Our Ref: R/2020/17/A
File No: 2022/059877
Your Ref: SSD-12618001

Request for Advice – 104-116 Regent Street, Redfern – Student Accommodation (SSD-12618001)

Notwithstanding the above, the **City has reviewed the accompanying documentation and objects to the proposal** in its current form based on the following matters:

1 Level 1 (Ground)
Floor Plan
1 : 200

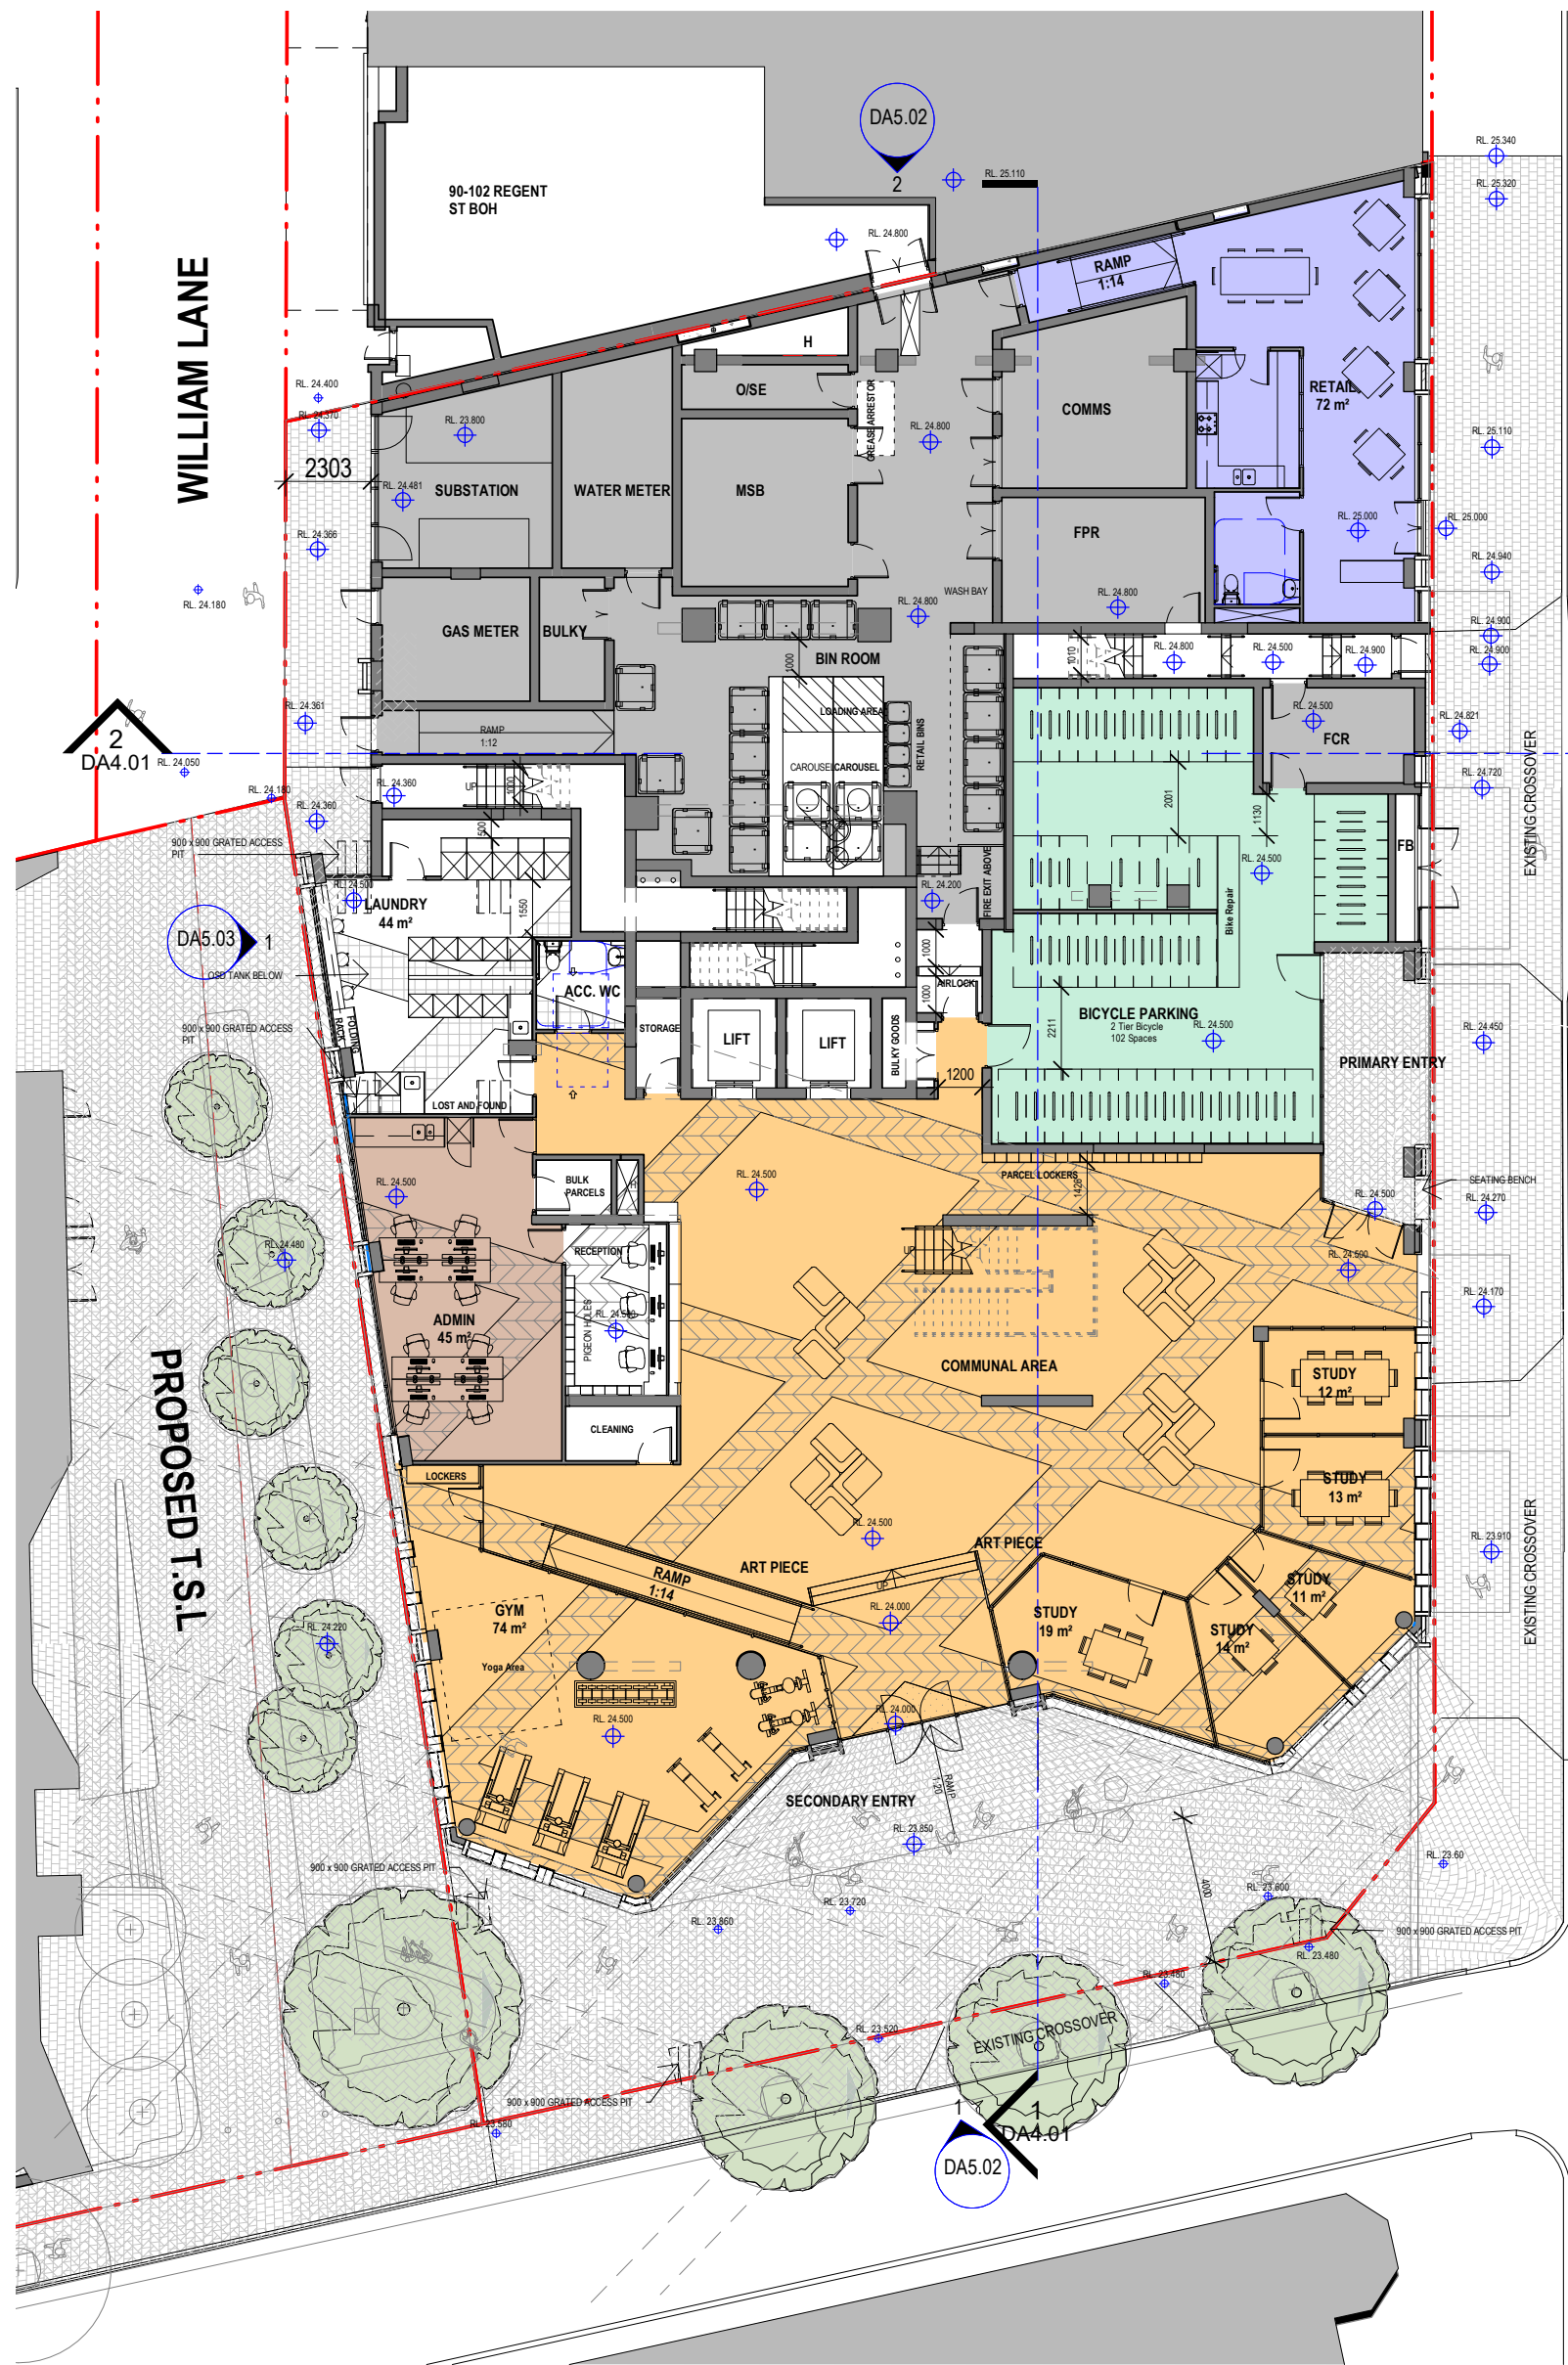
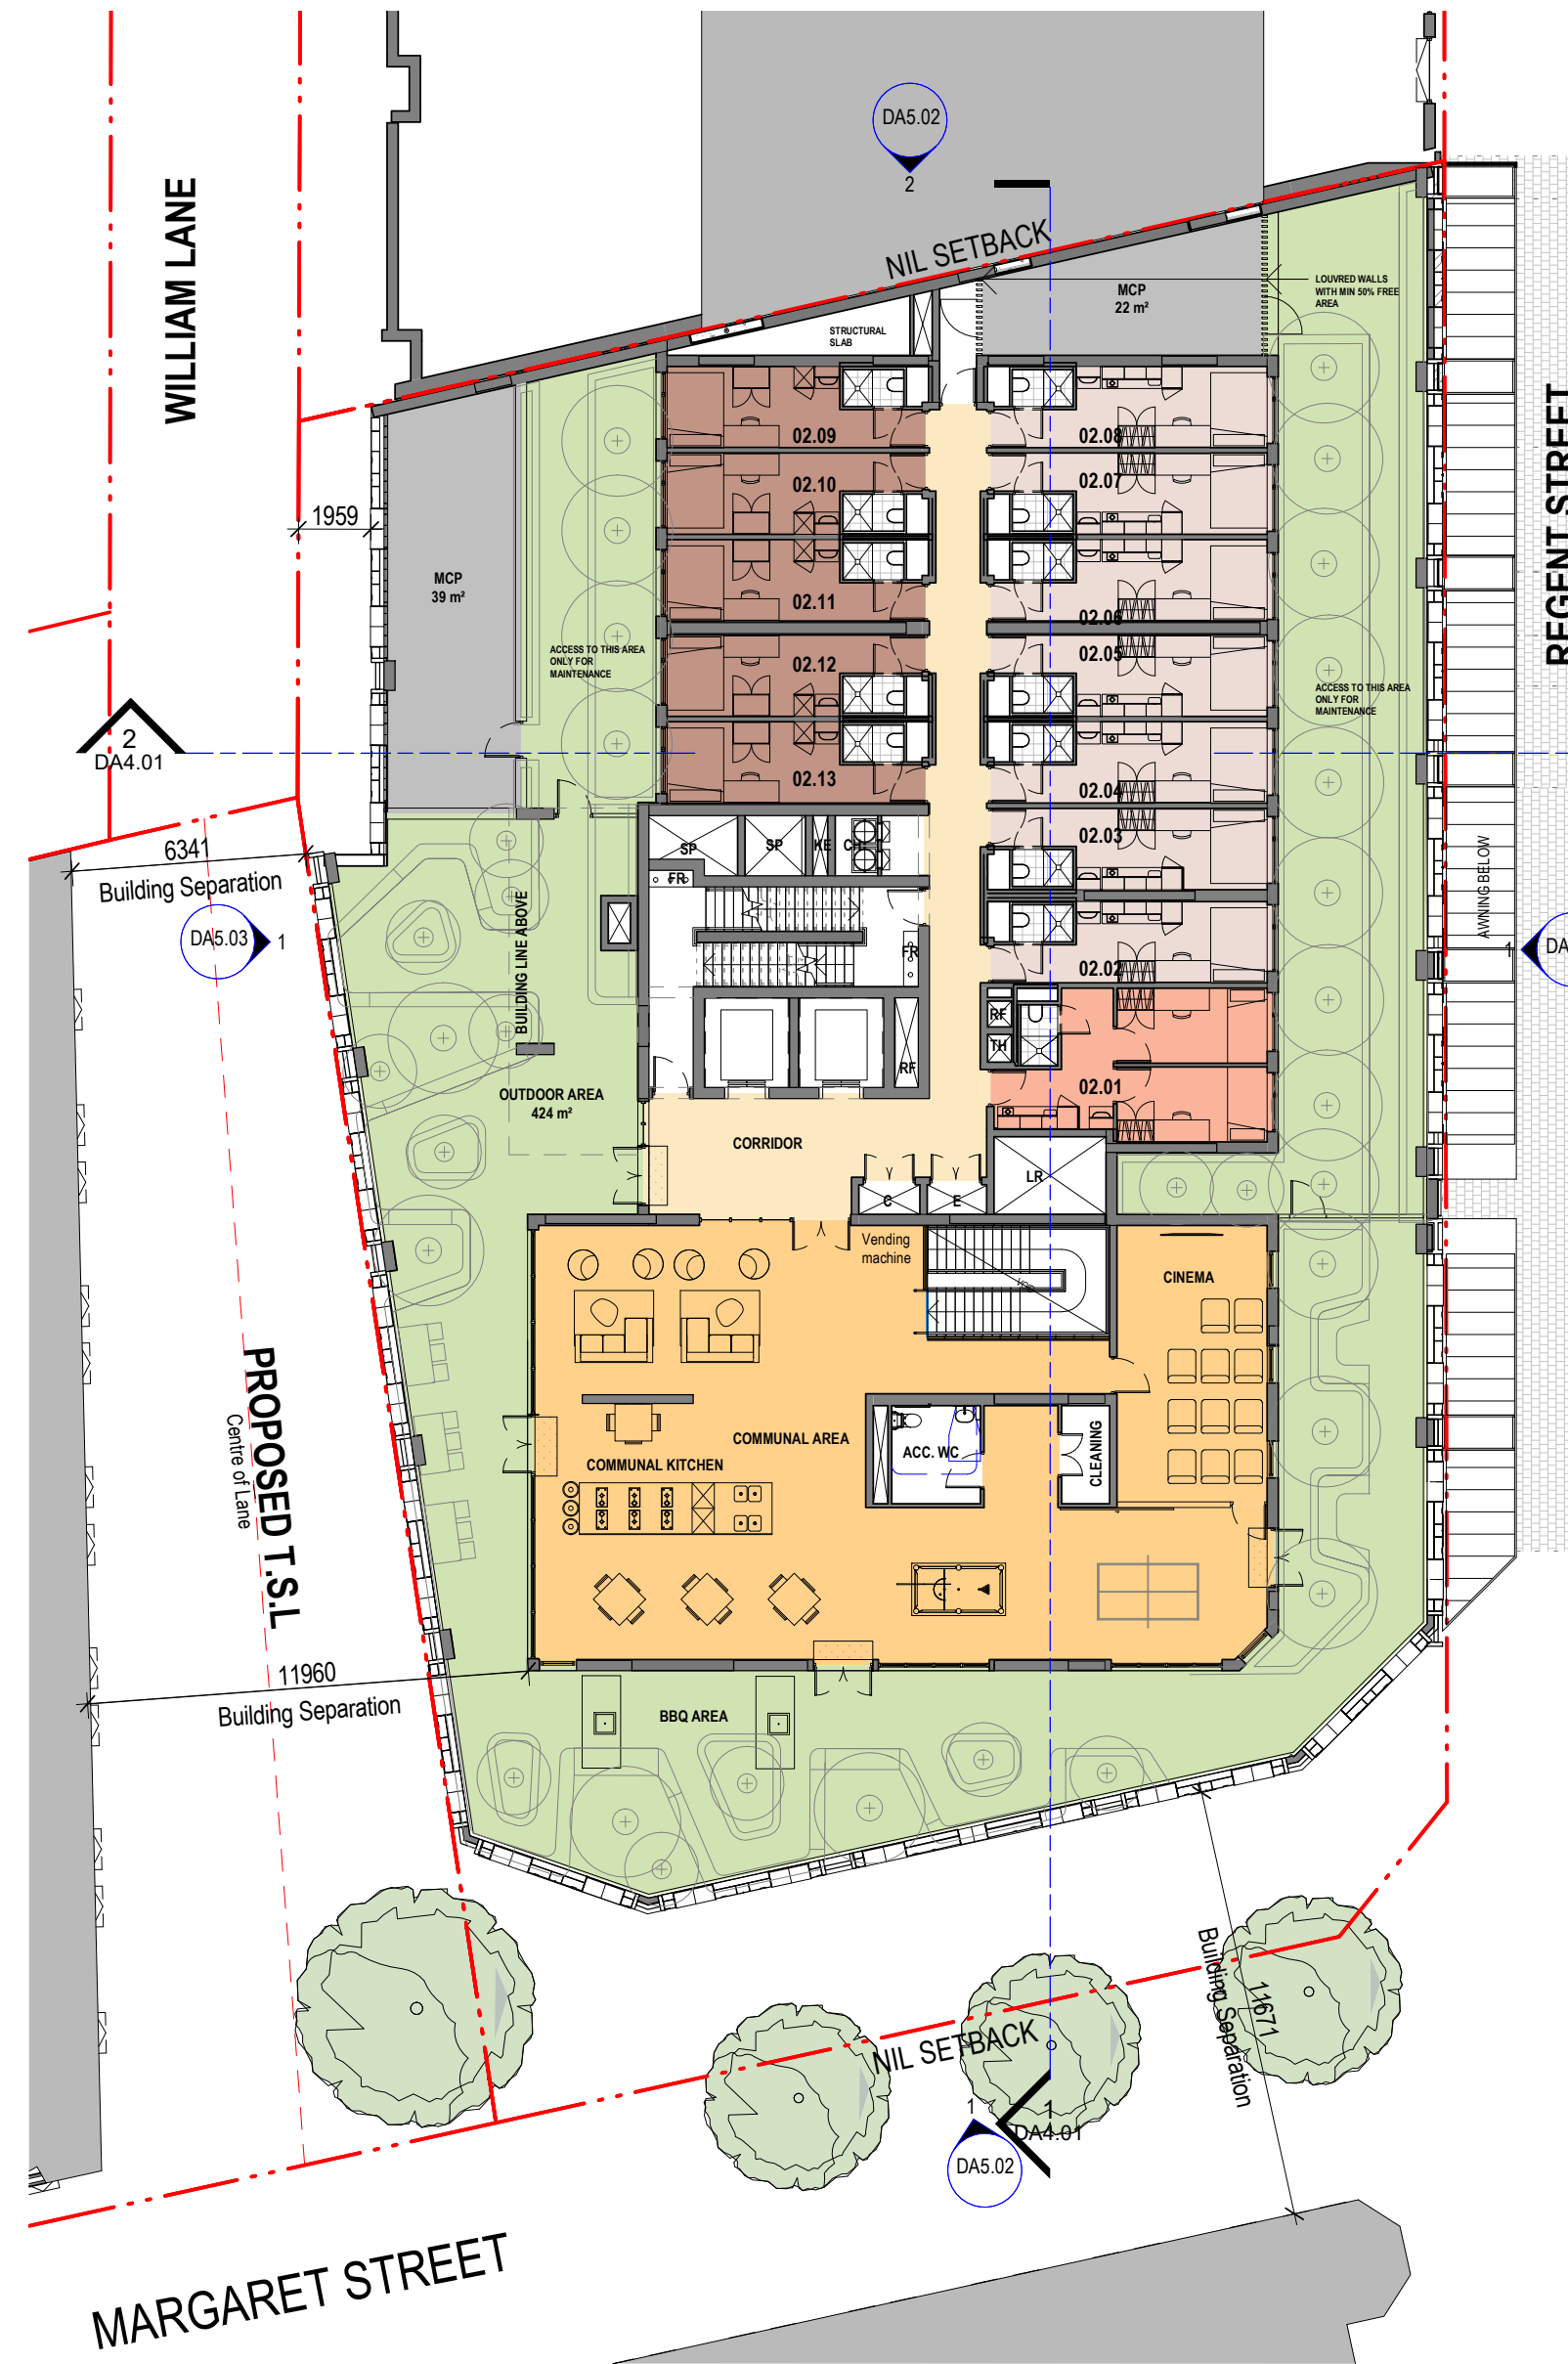
The Regent Street entry provides minimal passive surveillance as a result of the location of the bicycle parking facilities that occupy the majority of frontage. It presents areas of concealment with Crime Prevention Through Environmental Design (CPTED) concerns for both residents and the public. A small area of retail is located on the north-east corner. It provides a 3.8 metre floor to floor height and 2.8-metre-high window, which presents a more residential scale than commercial and does not maximise a genuine active frontage. A large fire booster cabinet is provided on the Regent Street elevation and does not adequately integrate with the façade.

The Margaret Street facade includes a recessed secondary entry, which sits in an undercroft of the podium. This fails to positively reinforce the street edge, would receive no natural light due to its orientation, and creates CPTED concerns for both residents and the public. The through site link facade also includes large areas of services with no entry point for activation.

The City recommends that these street frontages be redesigned to create safe and welcoming entrances with good passive surveillance, which positively contributes to the street. A more generous provision of retail area to the Regent Street frontage is also encouraged to increase genuine activation with increased floor to floor heights and glazing. An entrance point is recommended to be investigated on the through site link frontage to assist in activation of William Lane along with some food and beverage offering which has significantly more appealing acoustic environment away from traffic noise from the heavy traffic corridors of Regent Street and Gibbons Street.

DRAWING SERIES
Overall Plans
DRAWING TITLE
Roof Level / Plant Level

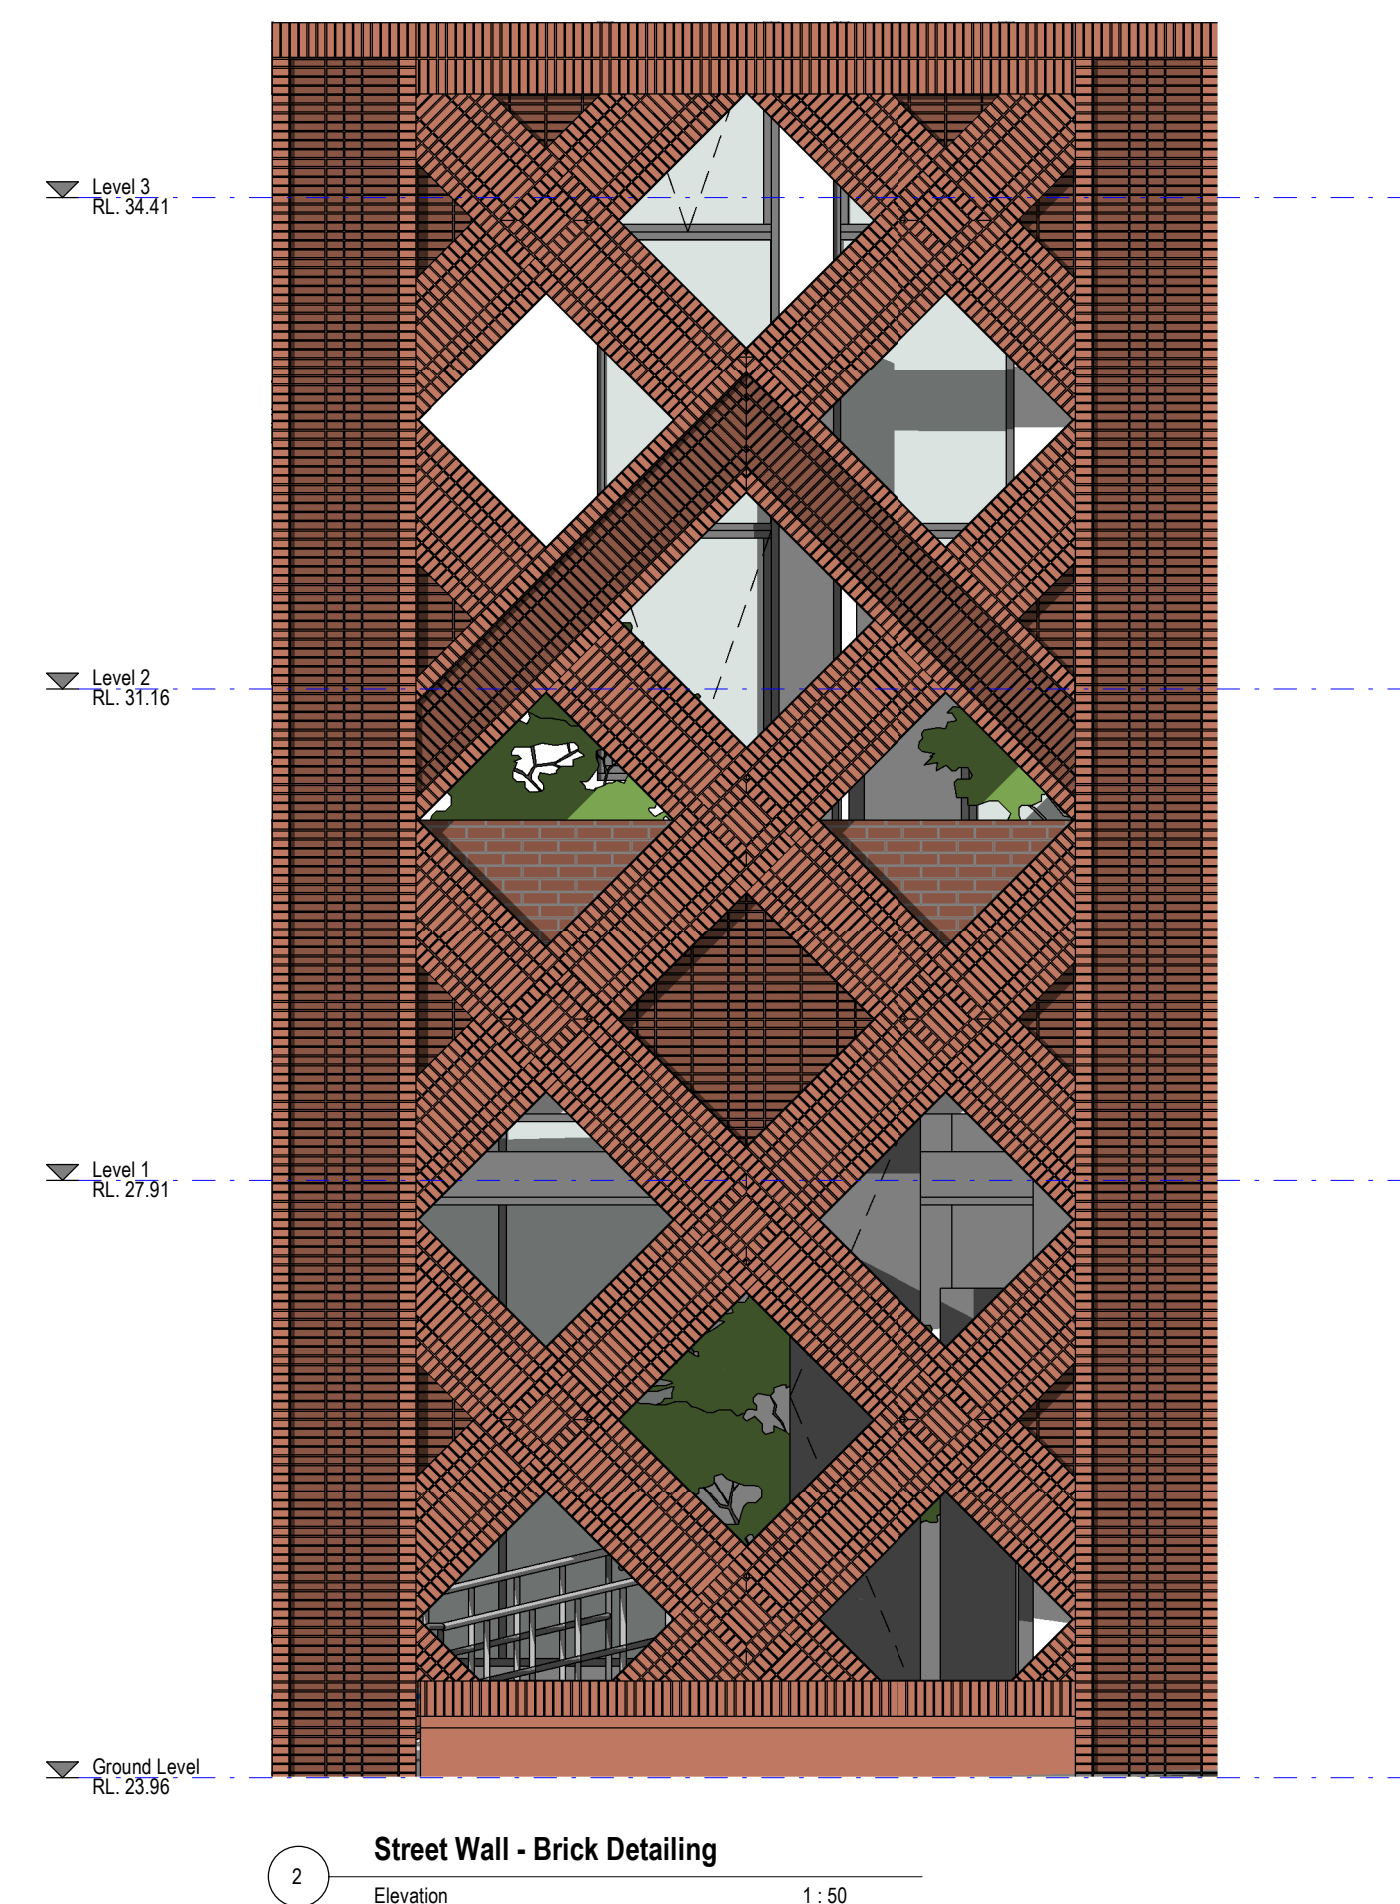
The site prescribes a height of buildings of 18 storeys under SEPP (State Significant Precincts) 2005. The proposal does not comply with the height control and presents a 19-storey development as plant is distributed across the full extent of the tower and contributes to a whole storey of visible bulk and scale. The maximum height is also higher than the development at 90-102 Regent Street, despite being lower in the street due to the fall of the topography. The City strongly recommends that the maximum height of the tower be lowered to match the neighbouring development, with plant to be designed into an 18-storey tower or substantially setback from the perimeter of the tower to reduce bulk and scale.

Further, there are discrepancies with the information submitted regarding the development's photovoltaic system. The submitted architectural plans indicate solar panels to be located on the roof. However, the BASIX requirements of 40-kilowatt peak capacity will require approximately 280 square metres of roof area. This is confirmed in Vipac's Ventilation Report, that suggests 130 panels are needed. The Report also indicates that the development will house an on-site battery system to store renewable energy. The proposal must verify this intent and confirm that there is adequate roof area to accommodate the required solar

panels. The system size in kilowatt peak is defined by BASIX and is not negotiable. Accordingly, the exact system sizing and configuration of the required solar panels must be confirmed and depicted in the architectural plans.
